Application for removal or variation of a condition following grant of
planning permission. Town and Country Planning Act 1990.
Planning (Listed Buildings and Conservation Areas) Act 1990

Development of a 64-bed Specialist Dementia Care Centre together with access, parking and landscaping (Use Class C2)

Arun District Council planning application ref: CM/16/18/PL

2, 3, 4, 5 and 9

drawing title:
M9316- HUN- 02- SL- DR- A- 13-0022

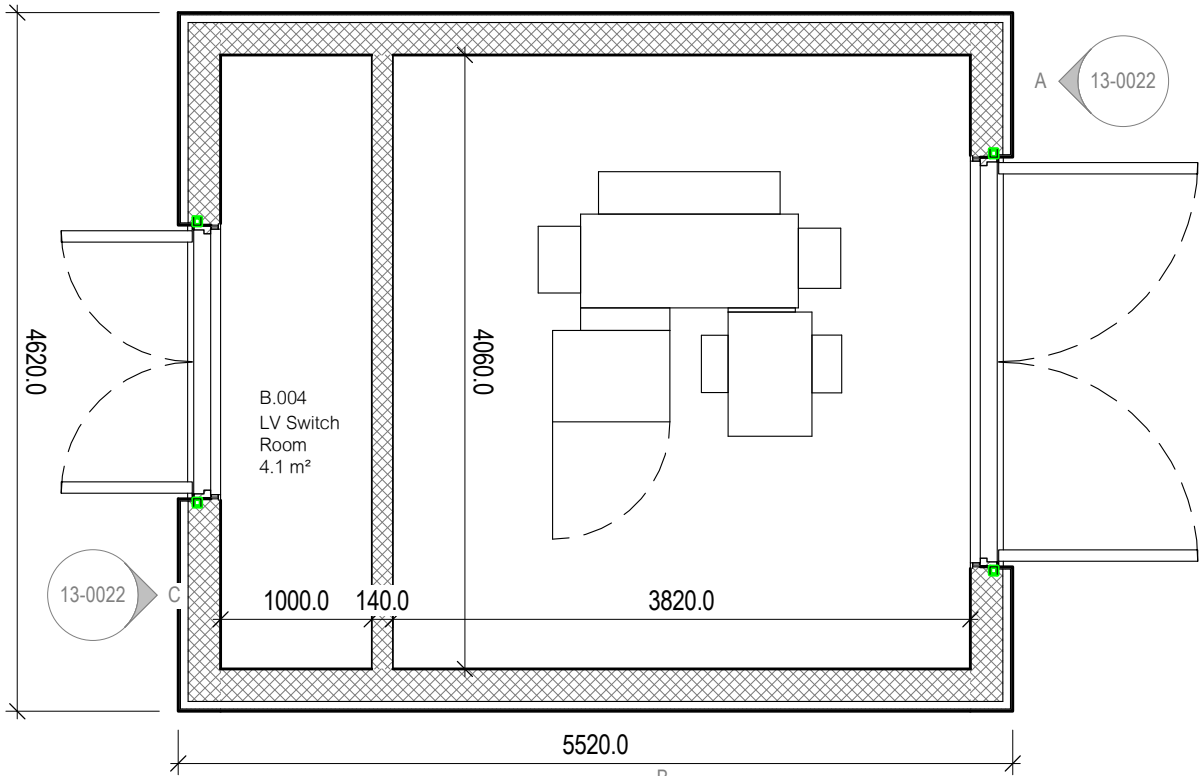
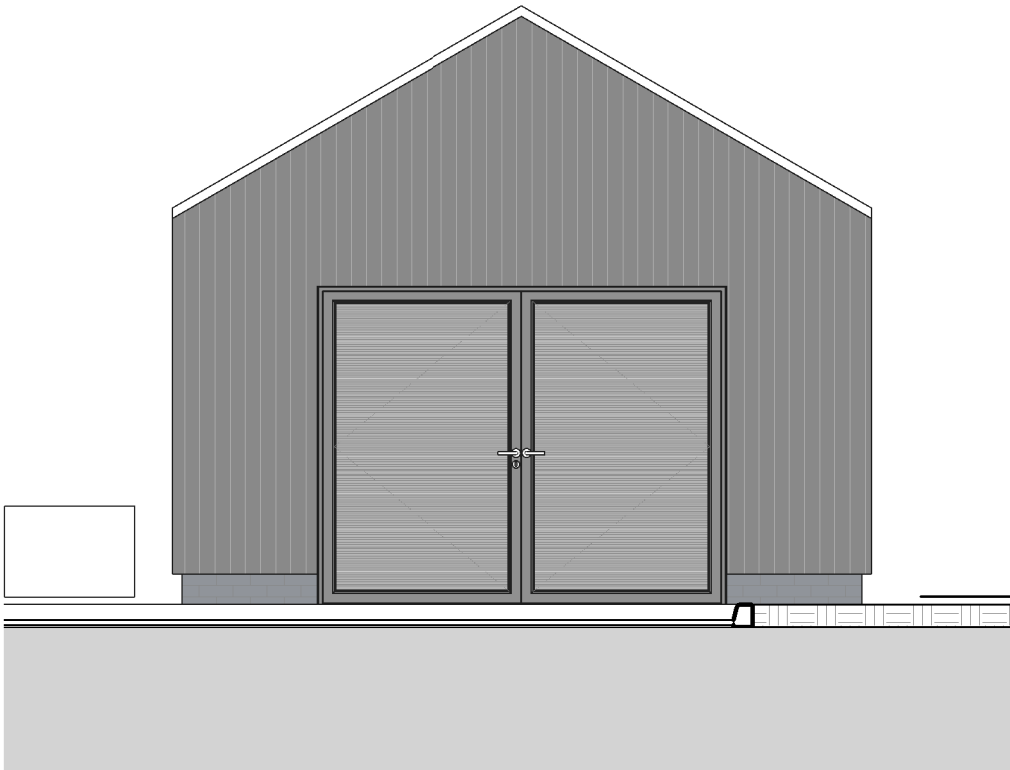
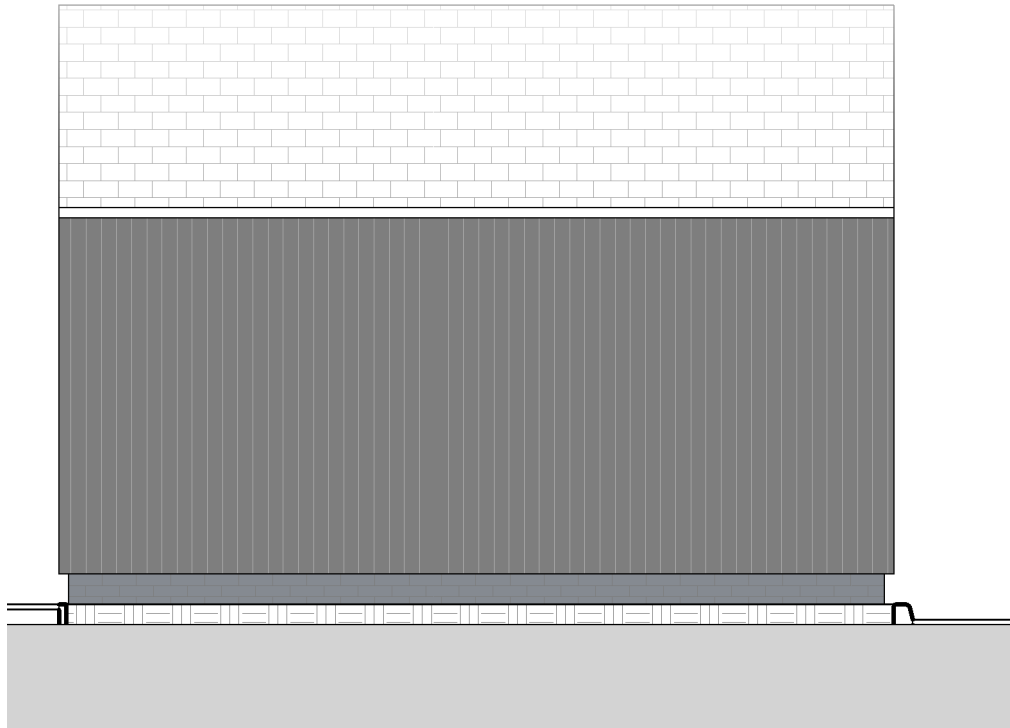
Condition 2 - Variation of the approved plans and drawings in order to introduce: an electricity substation onto the site, installation of air source heat pumps on the roof of the building, a reconfiguration of the car parking, and a change to the approved roofing material on the care home building.

An electricity substation is required in order to ensure the care home building is served by an all-electric supply of energy (heating and power) in the interests of energy efficiency. Air source heat pumps are to be installed as part of improving the energy efficiency of the building and facilitating the switch to an all-electric energy supply. Changes to the roofing material propose an alternative of similar appearance (Merayo Natural Slate) due to difficulties in sourcing the approved slate (Winchcombe grey roof tile). Changes are also proposed to the car parking layout to enable a more efficient use of the car parking area for the operator of the care home.

- Site Location plan dwg. APL001
- Proposed Site plan dwg. APL003 Rev. E
- Proposed Refuse & Recycling floors & Elevations plan dwg. APL004
- Proposed Ground Floor plan dwg. APL005
- Proposed First Floor plan dwg. APL006
- Proposed Substation dwg no. M9316-HUN-02-SL-DR-A-13-0022
- Proposed Northern Elevation NN plan dwg. APL008 Rev. B
- Proposed Eastern Elevation EE plan dwg. APL009 Rev. B
- Proposed Southern Elevations SS plans dwg. APL010 Rev. B
- Proposed Western Elevation WW plans dwg. APL011 Rev. B
- Proposed True Elevations plans dwg. APL012 Rev. B
- Site Sections plans dwg. APL013 Rev. A
- Landscape Strategy plan dwg. 11423/PO8c
- Proposed Highway Improvements dwg no. 025 Rev. P7

M9316- APL003

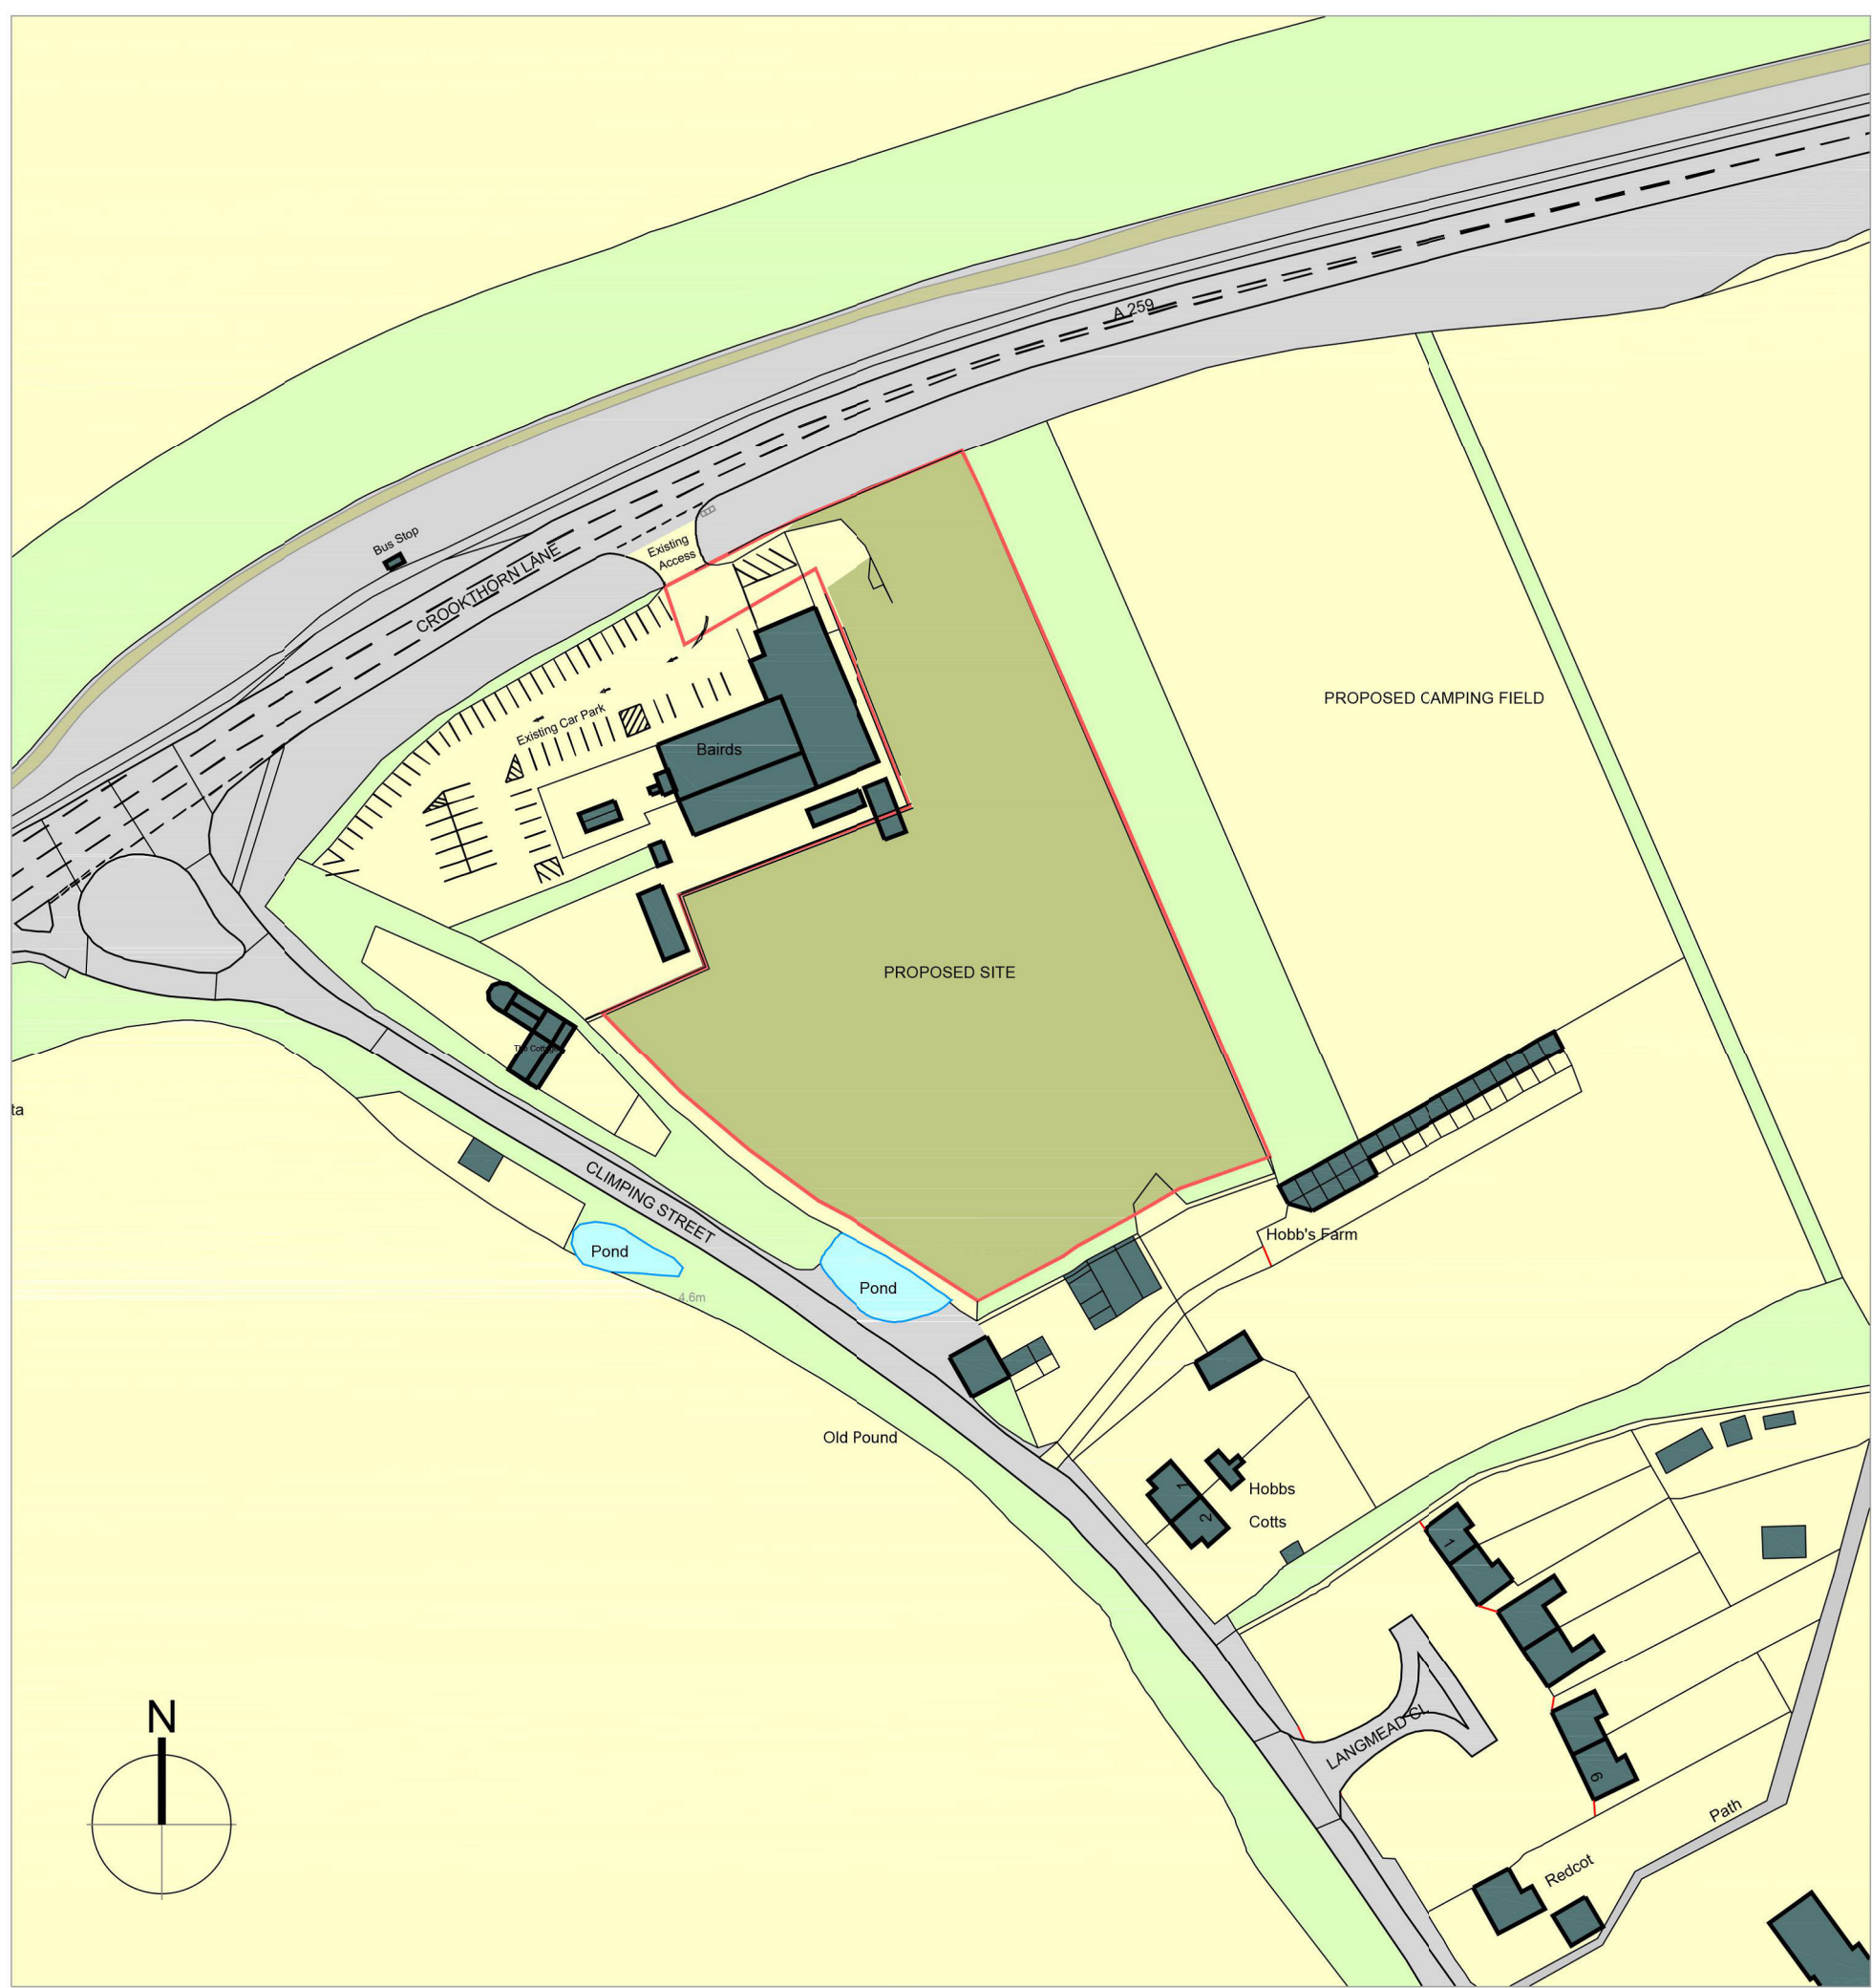
Condition 9 - Variation to require the car parking to be laid out in accordance with the site plan (dwg no. M9316-APL003 Rev. E) prior to the first occupation of the development and be retained as such thereafter.

Condition 9 - No part of the development shall be first occupied until the car parking has been constructed in accordance with that set out in the approved site plan (dwg no. APL003 Rev. E). These car parking spaces shall thereafter be retained at all times for their designated purpose.
